**From:** Deb Andrews  
**To:** Errico Thomas; Jean Fraser  
**Date:** 9/22/2014 12:28 PM  
**Subject:** Re: Fwd: Revised Wayfinding Plan for Marriott Courtyard

Vin has sent this plan as the final "Wayfinding" plan to meet the site plan condition- it reflects our meeting with him on site.

Attached is the revised wayfinding sheet. We added the signs on the upper part of Foundry Lane in the order in which we propose hanging them on the existing light poles. Does this revised plan work? If so, I will get the ball rolling with Marge and David.

**SIGNAGE &  
WAYFINDING PLAN**

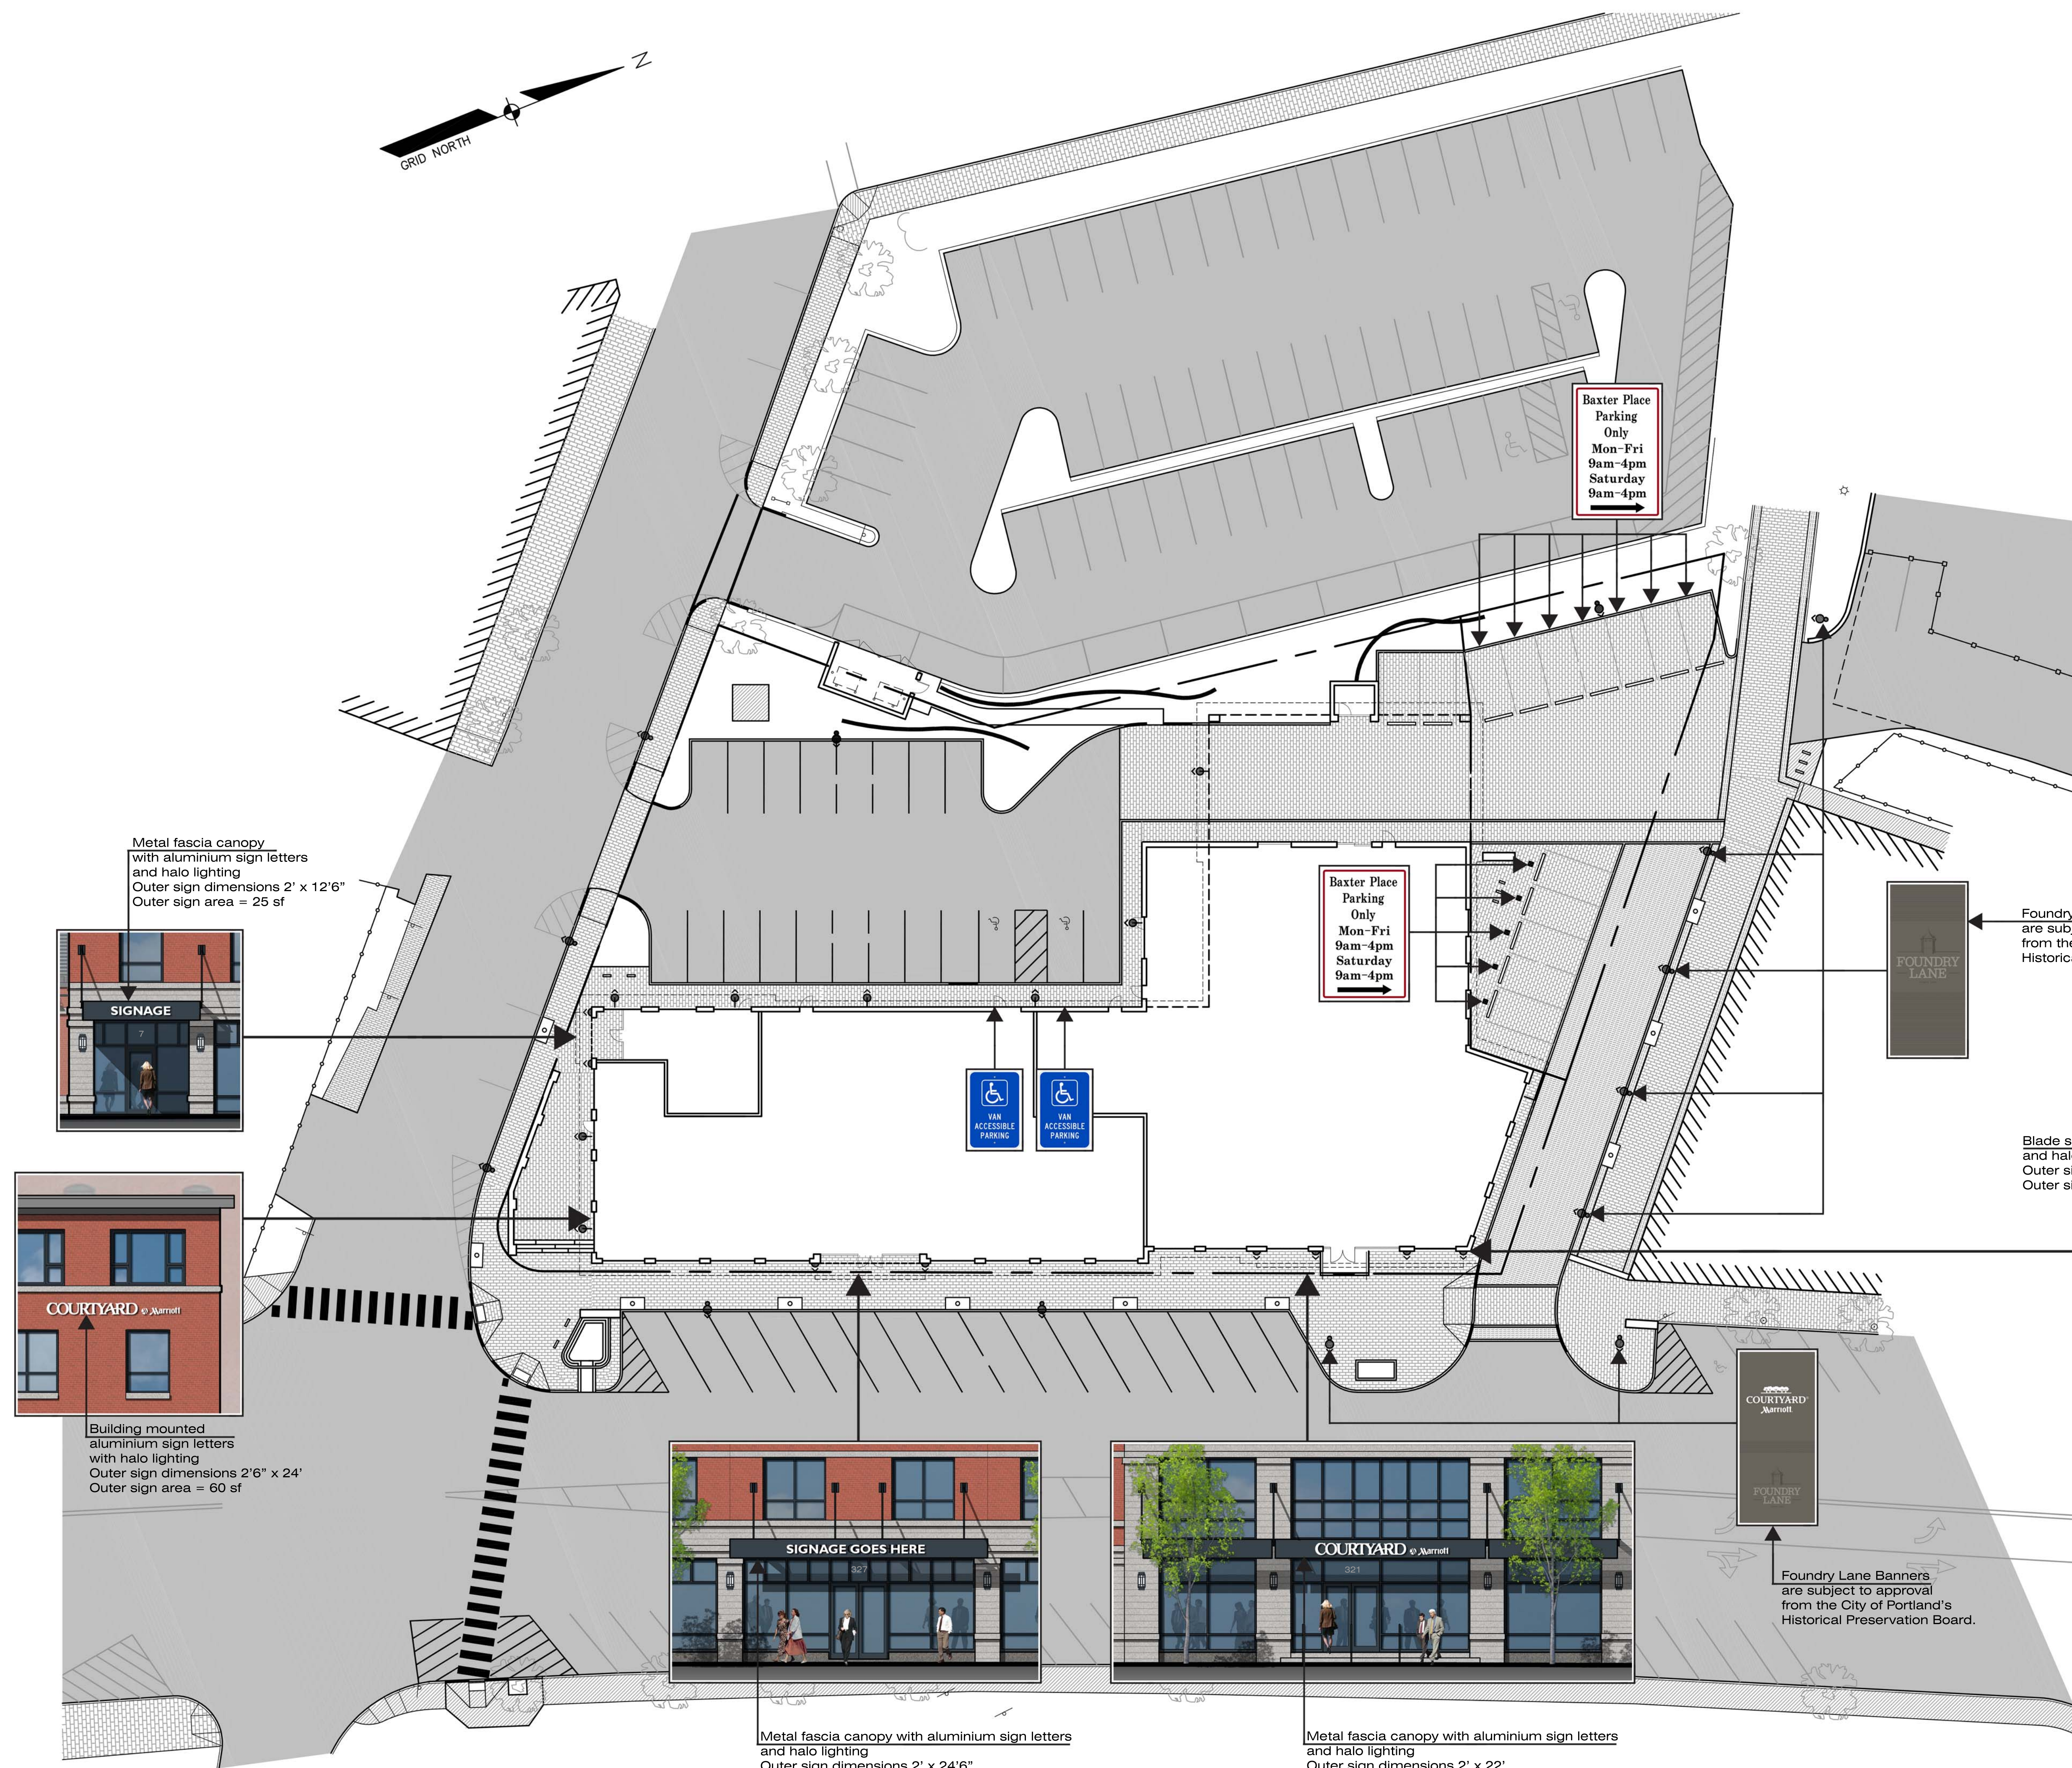
I just printed this out and was about to forward it to Tom when I noticed that the sign for the valet parking is not on this plan- and since its way-marking and of concern to Tom I think it needs to be included (just the one at Foundry lane).

Attached is the new wayfinding plan with the valet parking sign added. Do not hesitate to contact me with additional questions.
